Ann Machado - 93 Skylark Rd. - Lot 13 - Permit #2013-02107

From: Ann Machado
To: fdidonatomasonry@hotmail.com
Date: 10/3/2013 8:56 AM
Subject: 93 Skylark Rd. - Lot 13 - Permit #2013-02107
CC: Philip DiPierro

I just finished my review of the revised site plan that BH2M submitted. The building footprint now reflects the footprint on the building plans but there still are some discrepancies.

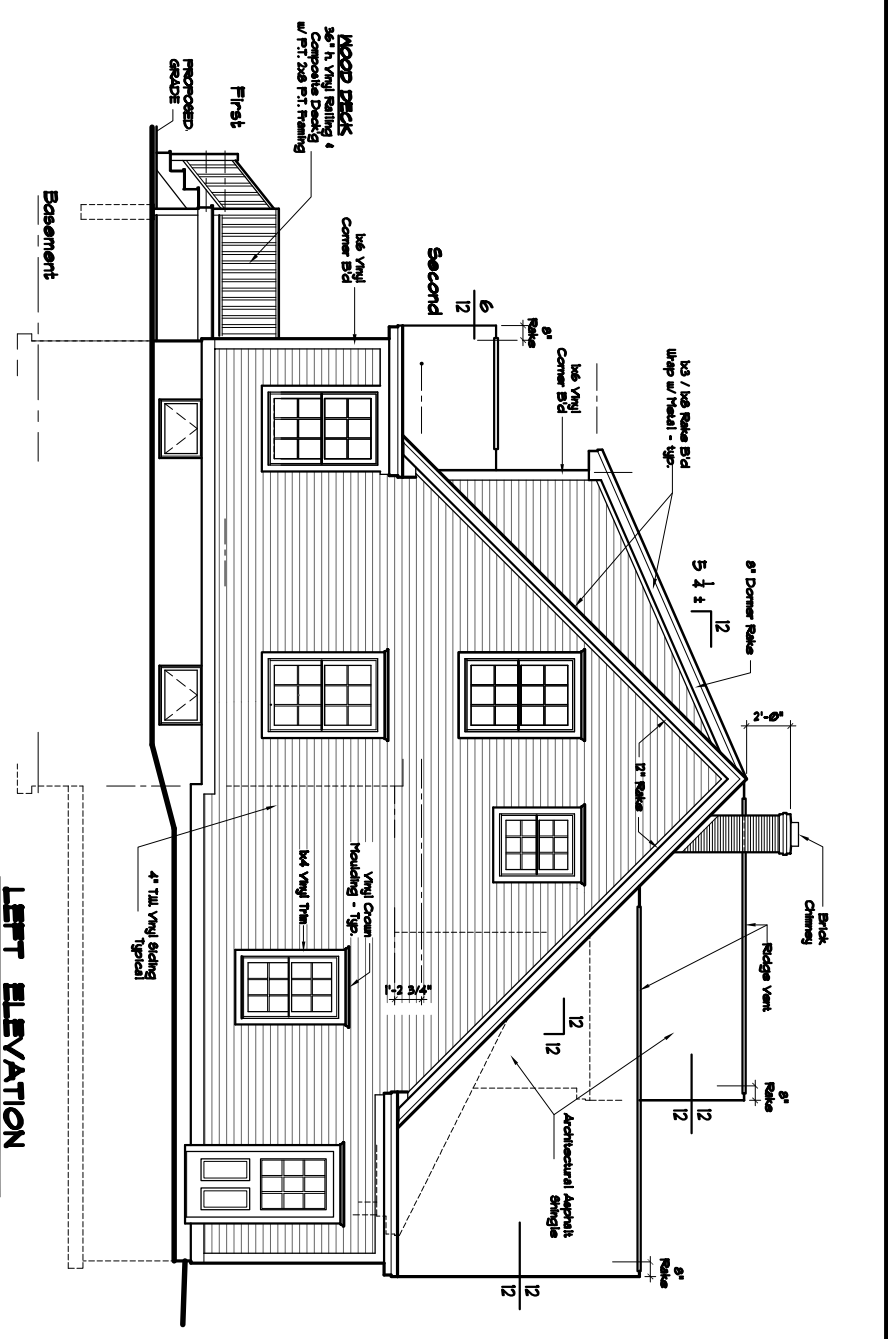
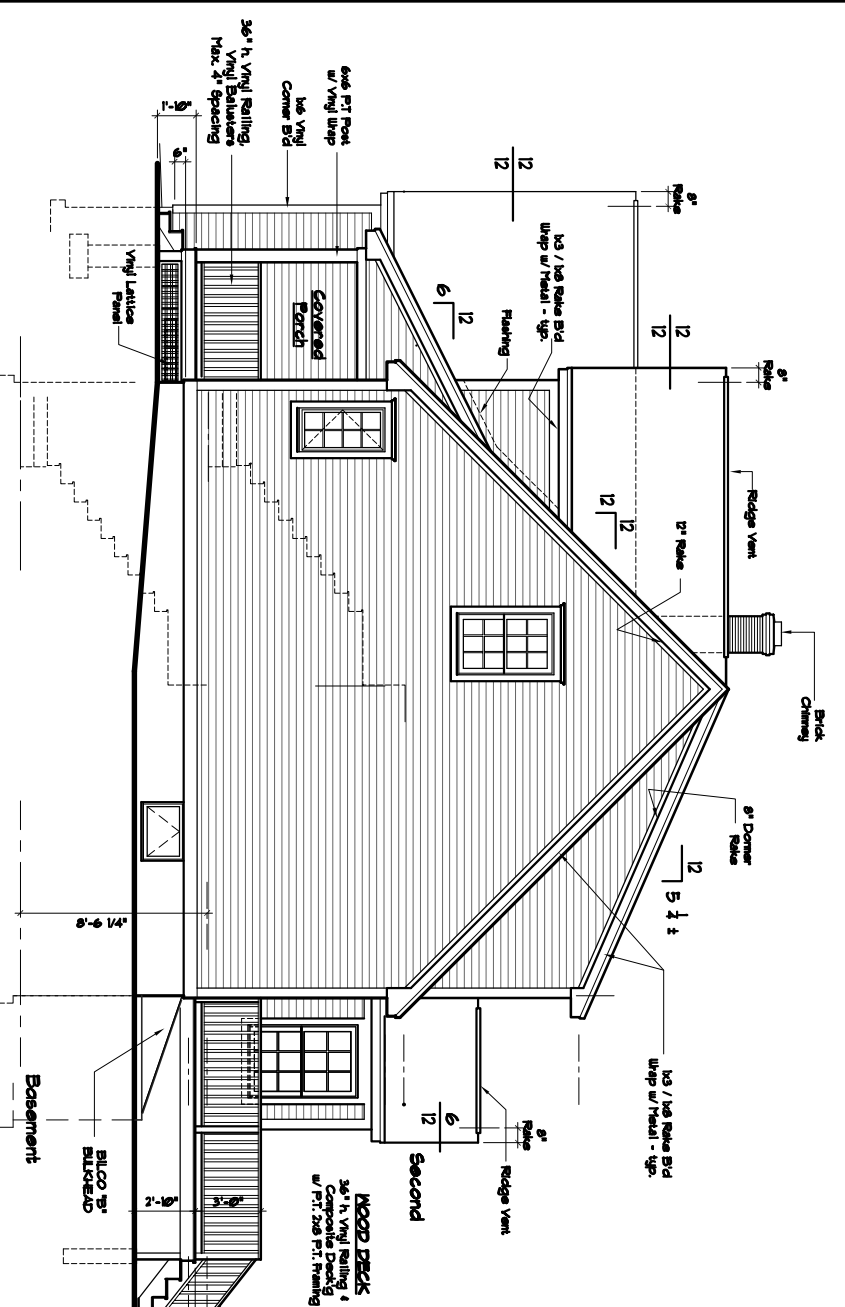
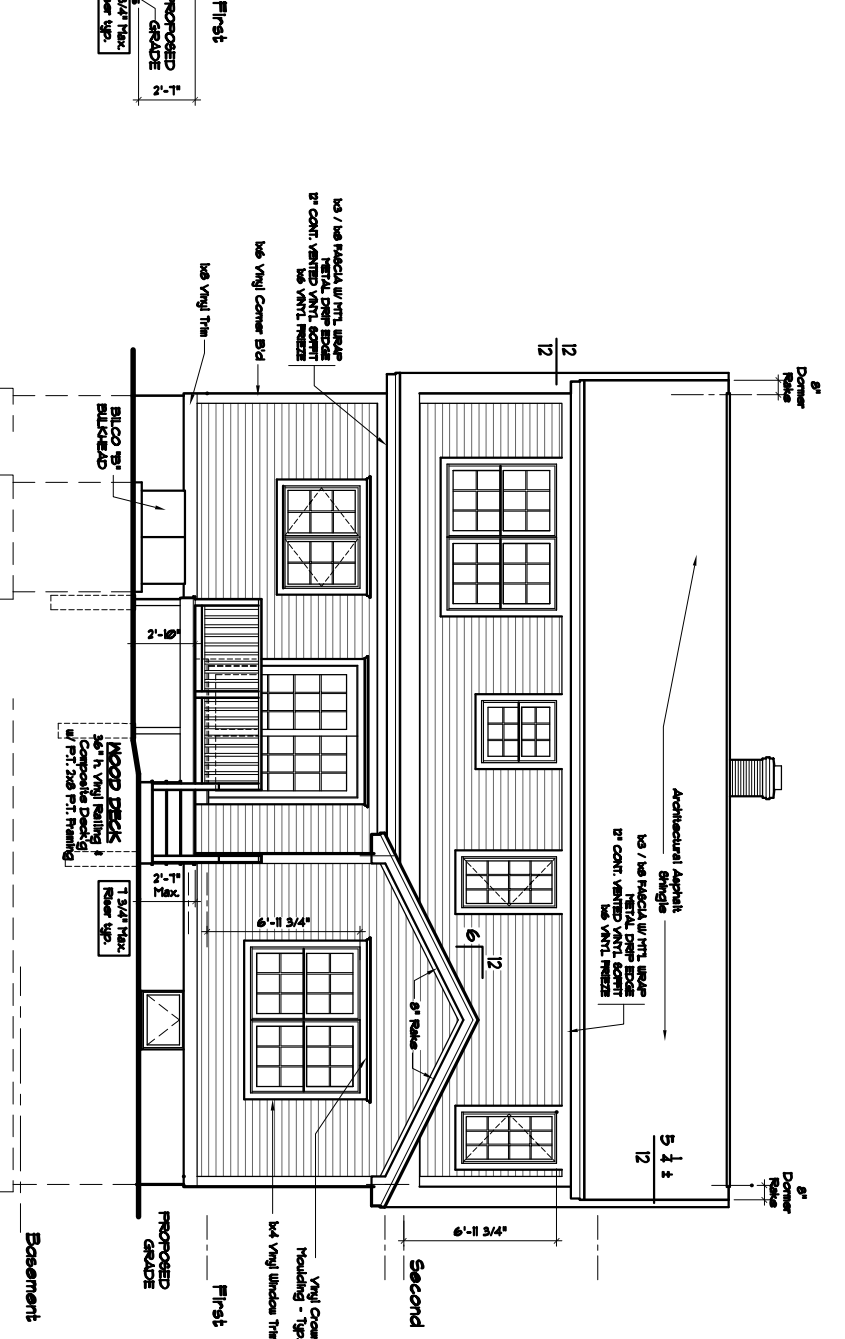
-The building plans show the deck as 12' wide and 10' deep. The elevation drawing shows the deck as 12' x 12'. Which is correct?

I would like to move this permit forward in the review process, but I need to know what size the deck is. If it is 12' x 10' please submit a revised elevation plan that shows this. The revised pdf should be emailed directly to me. Once I get this I will move the permit forward in the review process, but I can not do my final sign off for zoning until the site plan is correct.

<p>SITE PLAN-LOT 13</p> <p>SKYLARK COMMONS</p>		<p>FOR Frank Didonato Sr. 87 Skylark Road Portland, Maine 04103</p>	<p>BH2M Berry, Huff, McDonald, Milligan Inc. Engineers, Surveyors</p>	<p>STATE OF MAINE LICENSED PROFESSIONAL ENGINEER LESTER S. BERRY, P.E. No. 3341</p>

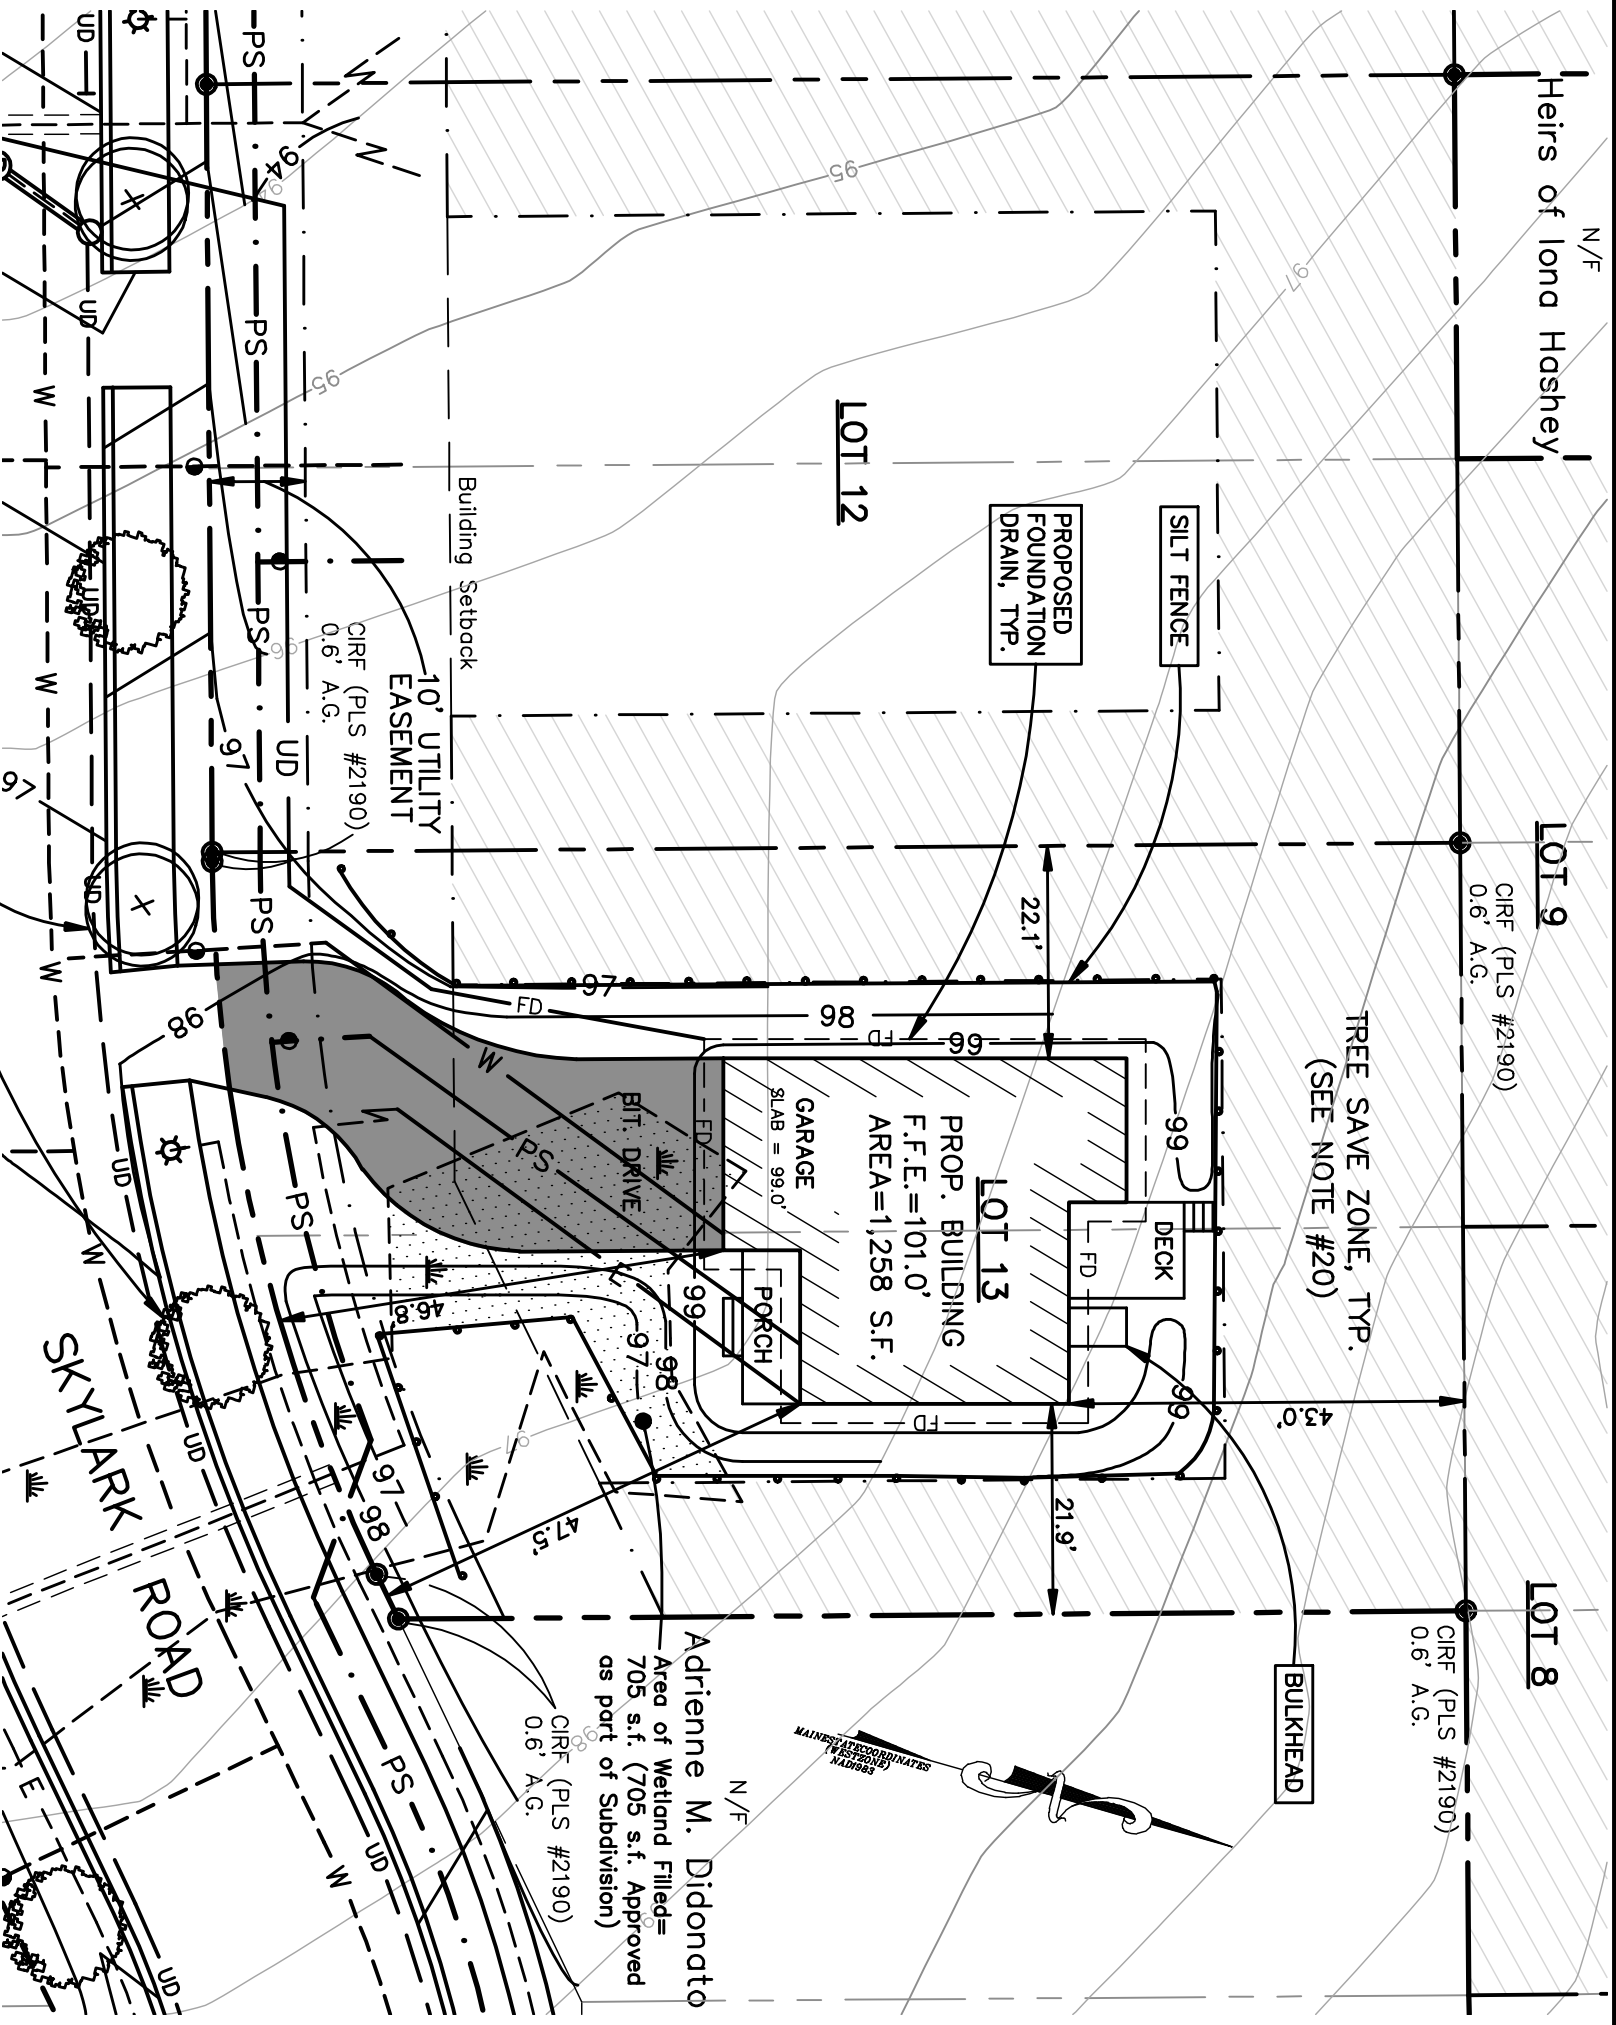
-The building plans show the footprint of the deck as 12' wide extending off the building 10'. The site plan shows the deck as 10' wide extending off the building 12'. I assume that the building plan is correct and therefore the site plan needs to be revised to match the building plan.

-The bulkhead is now shown on the site plan but the size does not match what is on the building plans. The bulkhead on the site plan scales at 6' x 4'. The bulkhead on the building plan is 6'4" x 5'4". Please revise the site plan to address this.
